**Consultation Response from KC,
Lead Local Flood Authority**

2026/90240 Huddersfield Bus Station, Upperhead Row, Huddersfield, HD1 2JN

Discharge of details reserved by conditions 12 (phase 1 surface water management), 17 (external plant or machinery), 31 phase 1 bus disruption plan) and 32 (phase 1 foundation proximity to railway) of permission 2025/91604 for Variation of condition 12 (surface water mitigation), 17 (plant and machinery), 31 (disruption plan) and 32 (foundations) on previous permission 2025/91604 for Variation condition 2 (plans) on previous permission 2024/92302 for refurbishment comprising (phase 1): facade improvements including Henry Street entrance; replacement shop fronts; alterations to external bus apron; extension and alterations to existing barrier within the bus alighting lane adjacent to Henry Street; (phase 2): new entrance canopy; public realm improvements; cycle hub; facade improvements including replacement shop fronts

Title: Apron Layout Drainage

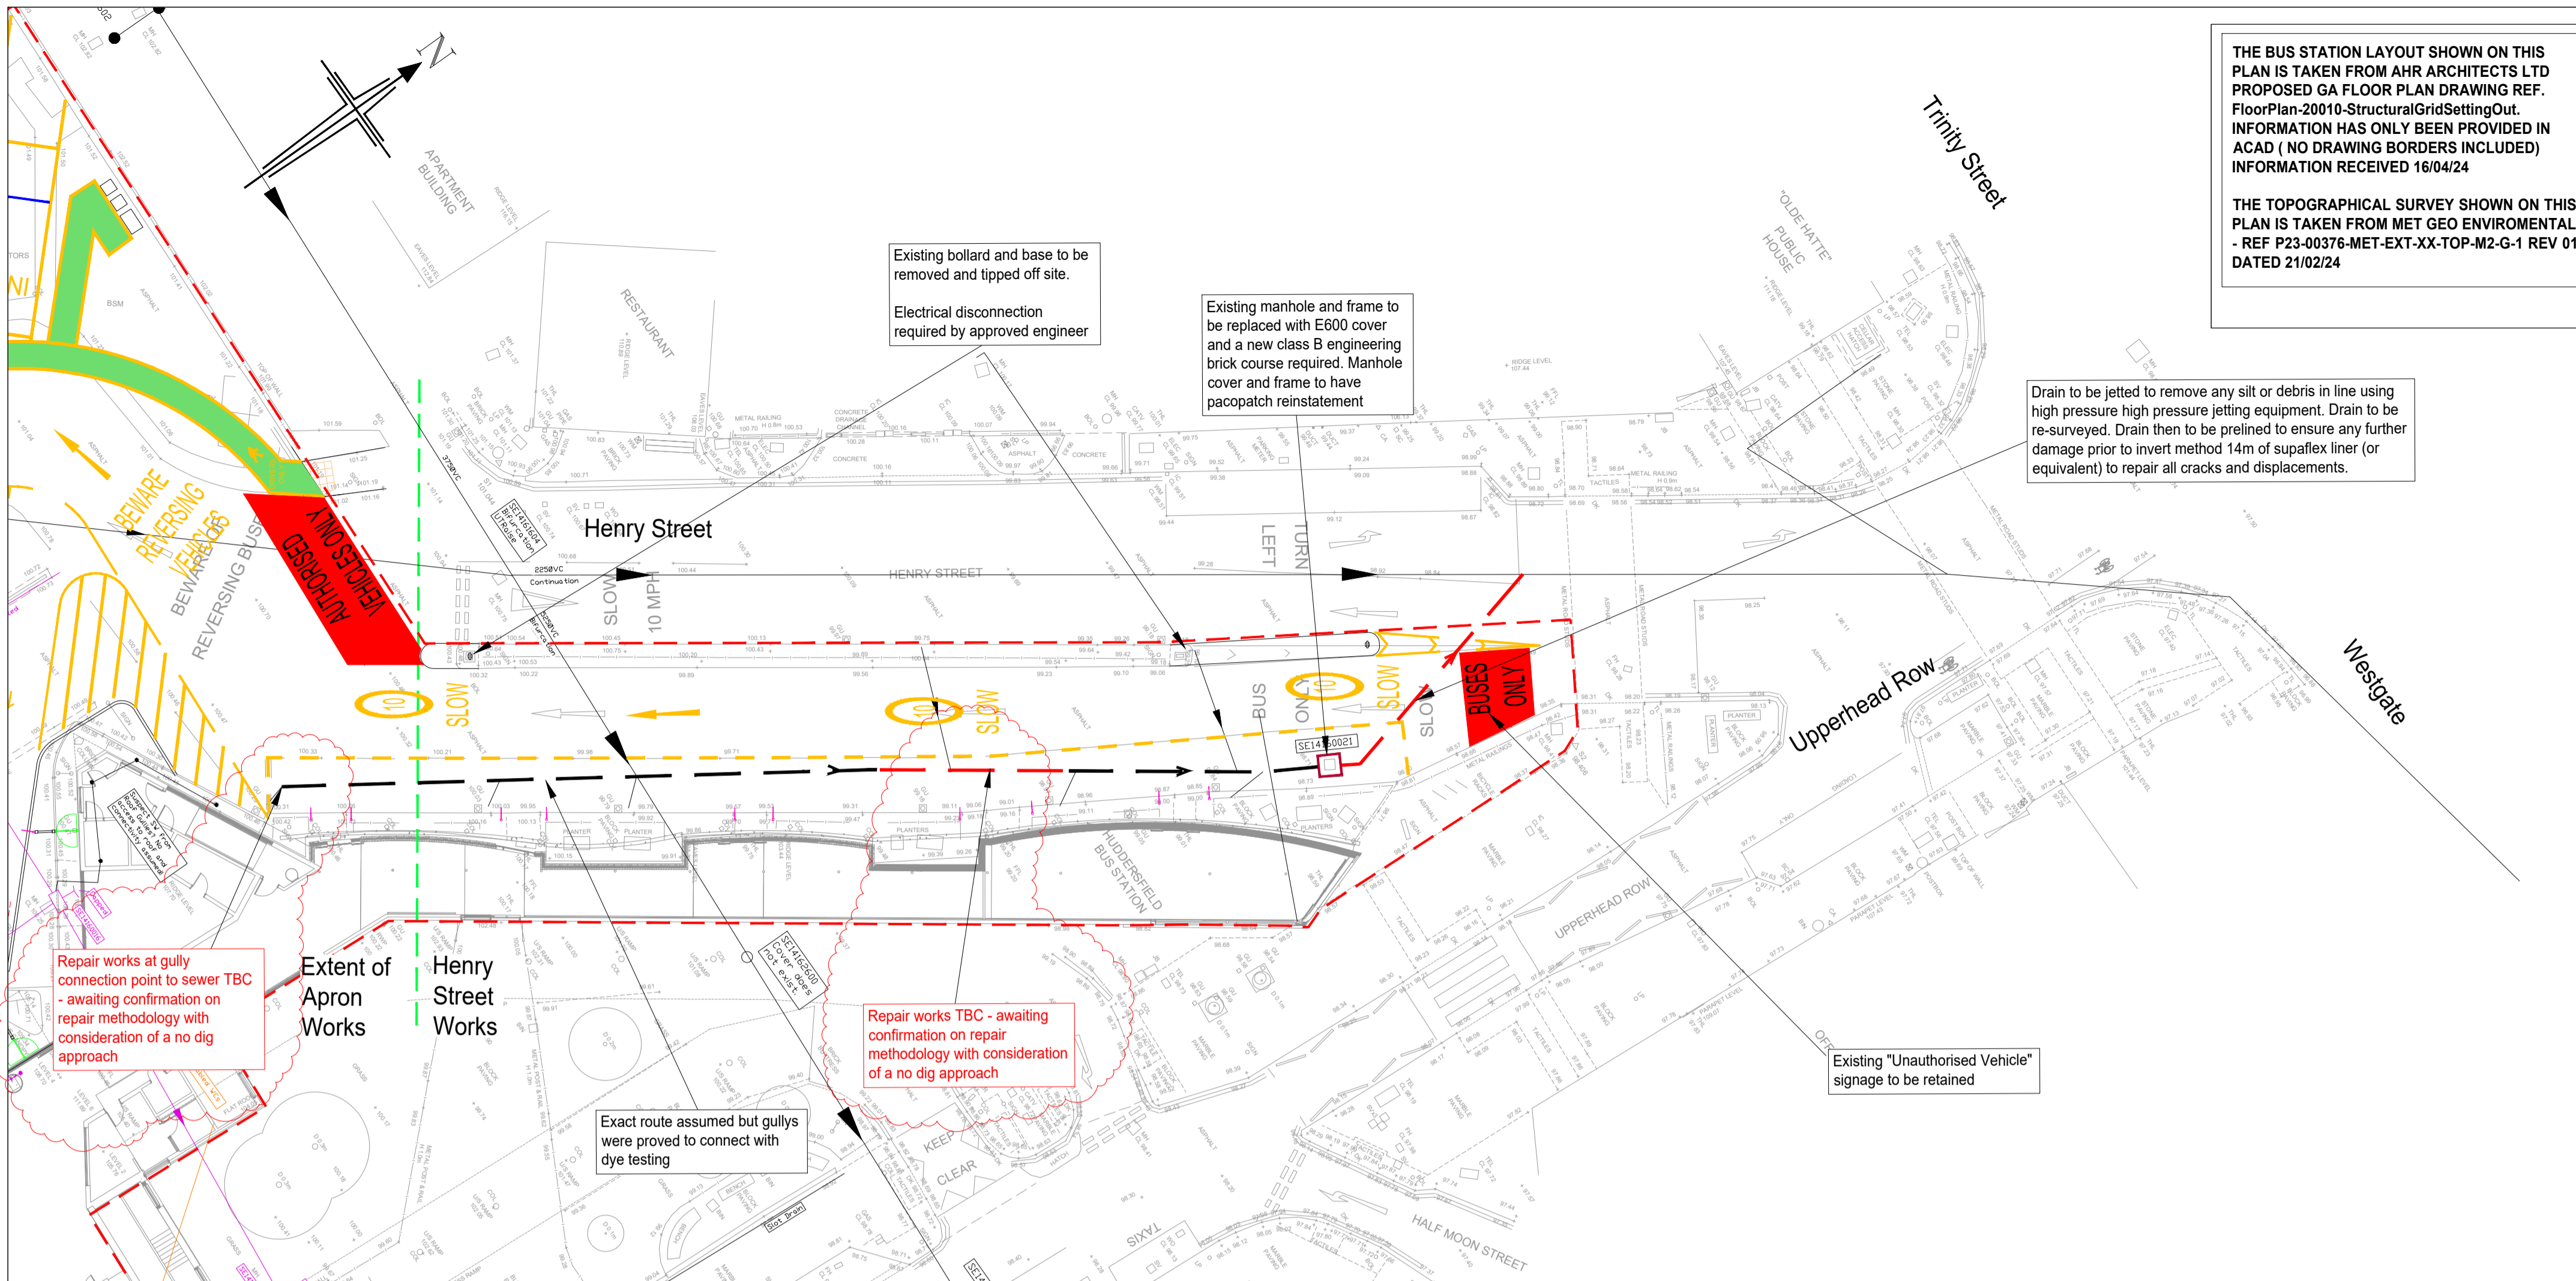
The condition is different to the one recommended by the LLFA. The drainage proposal principle was accepted in accordance with those promoted in the drainage and flood risk strategy. This included our quote:

“If there is no increase between the current road/hardstanding impermeable areas positively draining to sewer compared to the new road/hardstanding impermeable areas then I would not consider it necessary to introduce attenuation storage for these areas provided the existing connections to the YW sewer are re-used.”

We are satisfied that this still applies and do not wish to make further comment. The wording of actual condition states ‘not withstanding’ details promoted in the document quoted above. If the planning officer was of the mind to look for additional requirements, then the discharge of condition rests with them.

In the meantime we recommend that this condition CAN be discharged.
